**Your Ref:** OWPC18201  
**Our Ref:** M/41/18/HH 22-03-2018  
**Please ask for:**  
Zac Denton

Extension to 1st floor incorporating rooms within the roof space for new 2nd floor & single storey rear extension with balcony above.

25 Sea Way Middleton-On-Sea

PROPOSED ELEVATIONS

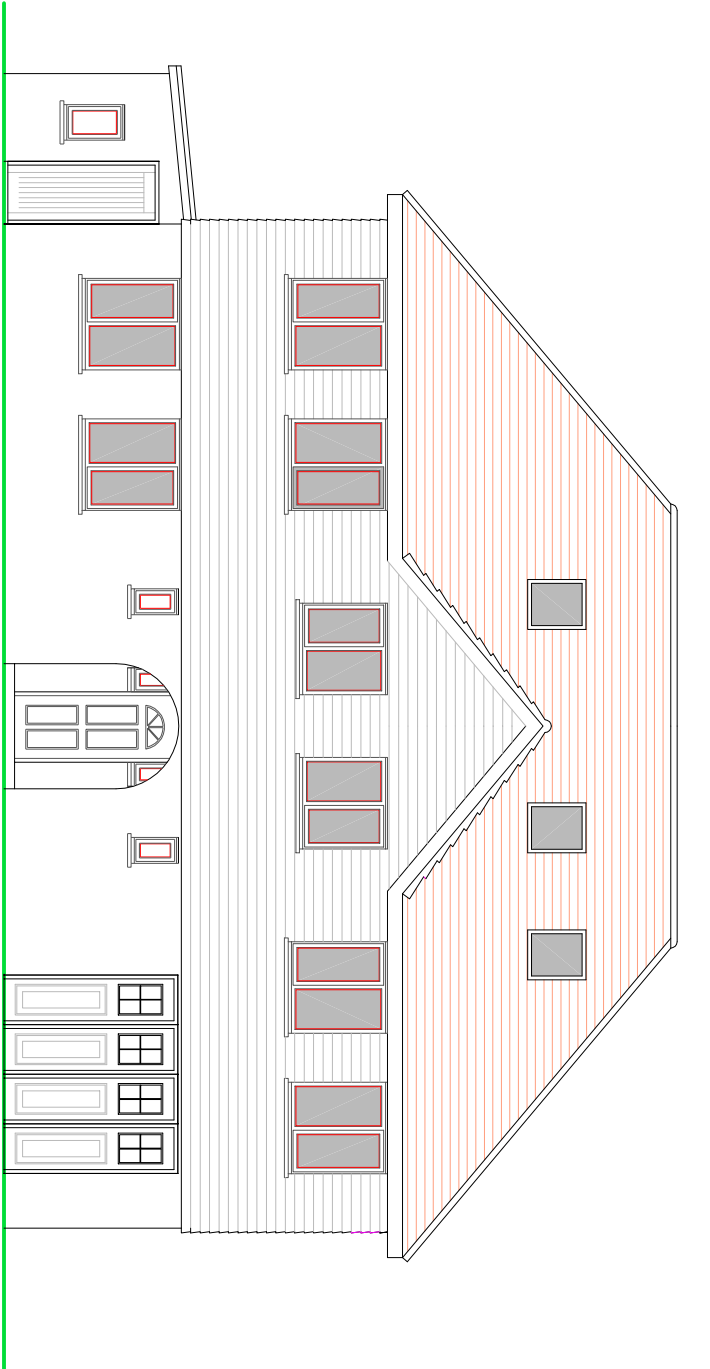
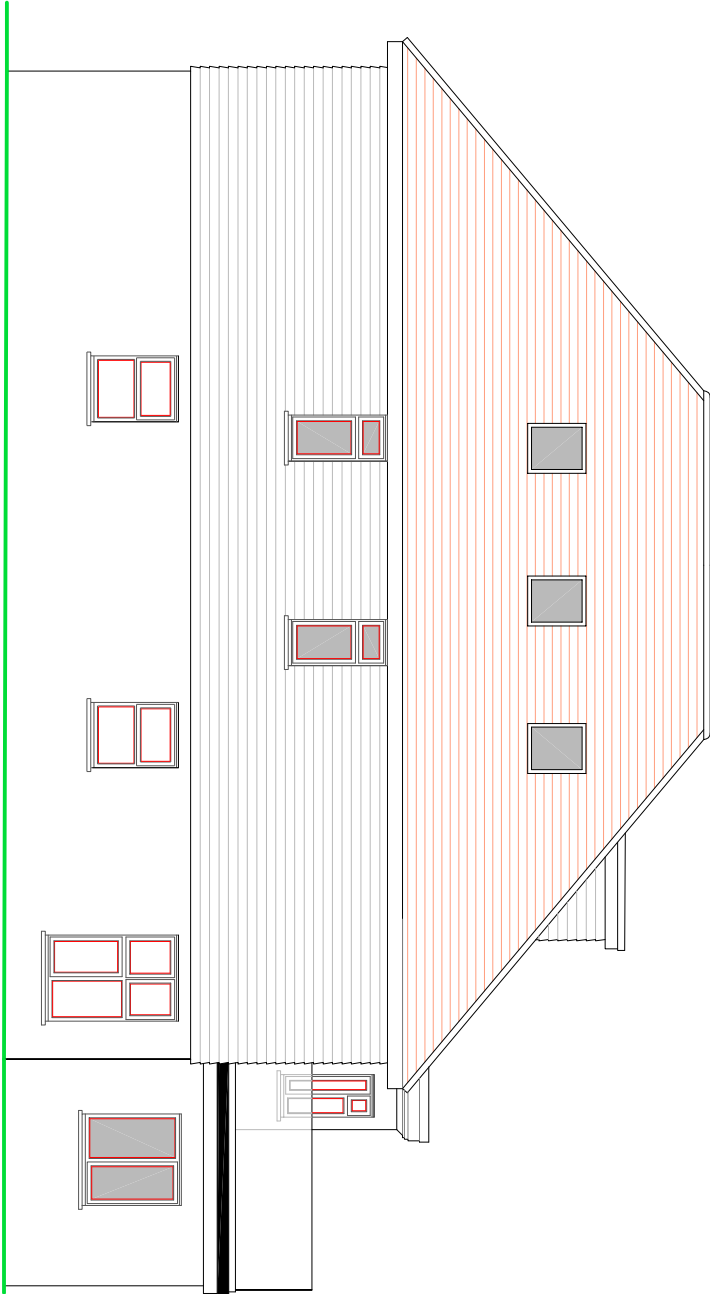
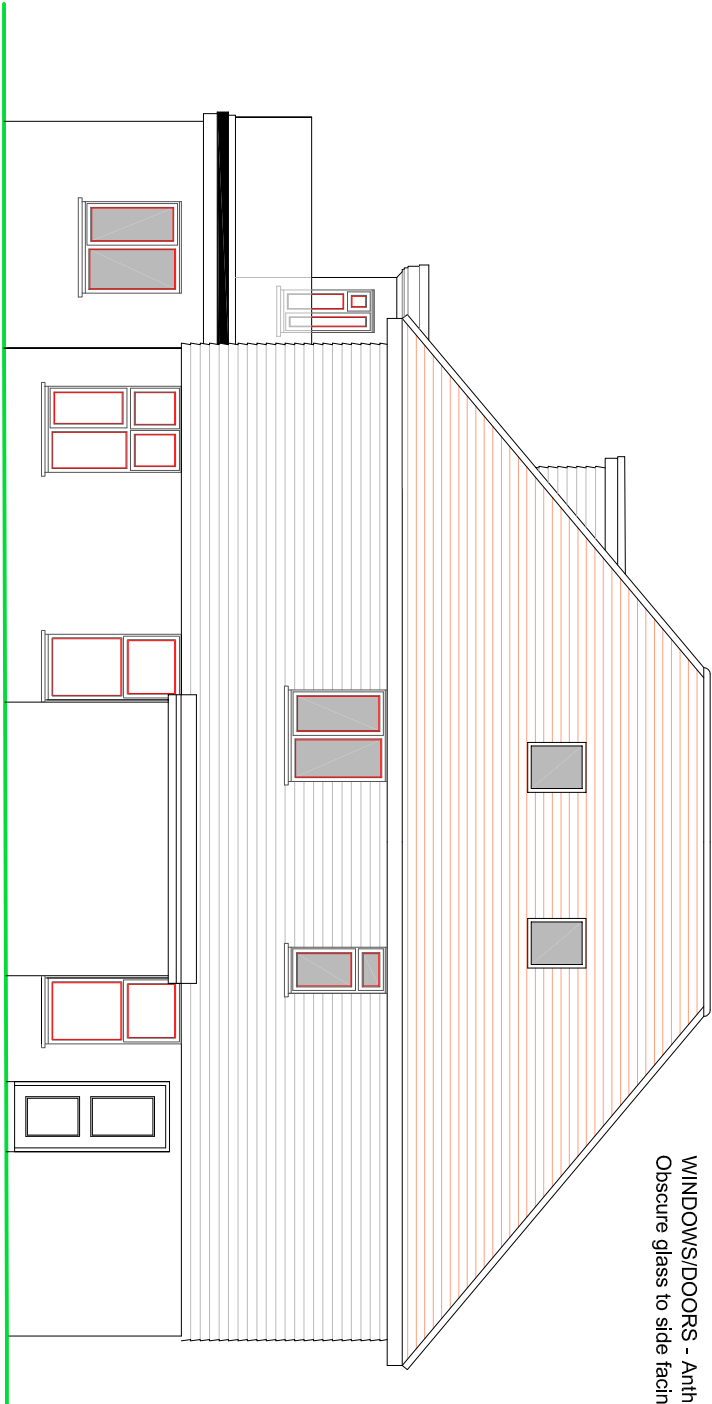
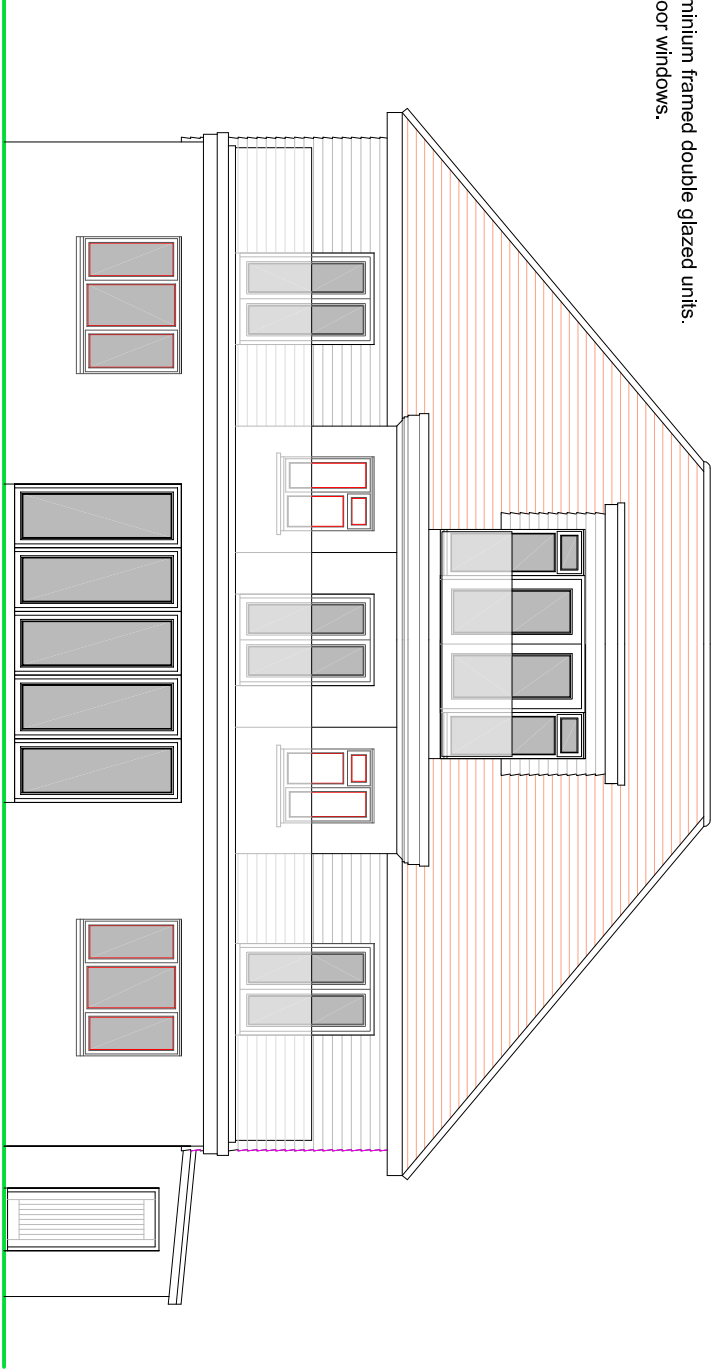
*The proposed development is proposing an approximately 15% increase in the height of the property at 25 Sea Way and would, in effect, establish the dwelling as a 3 storey property above ground level.*

*Other than the increase in height of the property, the plans reveal there will be a first (ground) floor, a second floor and then a new third floor with doors leading onto a balcony / terrace.*

*The proposed terrace on the third floor will give commanding views over the beach to the sea, but also over and into, neighbouring properties.*

*The proposal appears to be contrary to a number of ADC planning policies, including supplementary planning guidance in the Middleton on Sea Village Design Statement which states, in the Design Guidelines, that three storey houses are not in keeping and must be avoided. Further, that skylights should be avoided in front elevations.*

*The plans propose skylights in the roof, which is clearly contrary to the guidelines.*

*The dwelling, as proposed would be out of character and also out of scale with surrounding properties. It will adversely impact the street scene. It would cause serious intrusion and invasion of privacy of immediate neighbours.*

*Three storeys would be excessive in the location. Permitting a balcony / observation platform at that level would make the property extremely un-neighbourly, with commanding views over and into adjacent properties and over other properties for a significant distance along the sea front.*
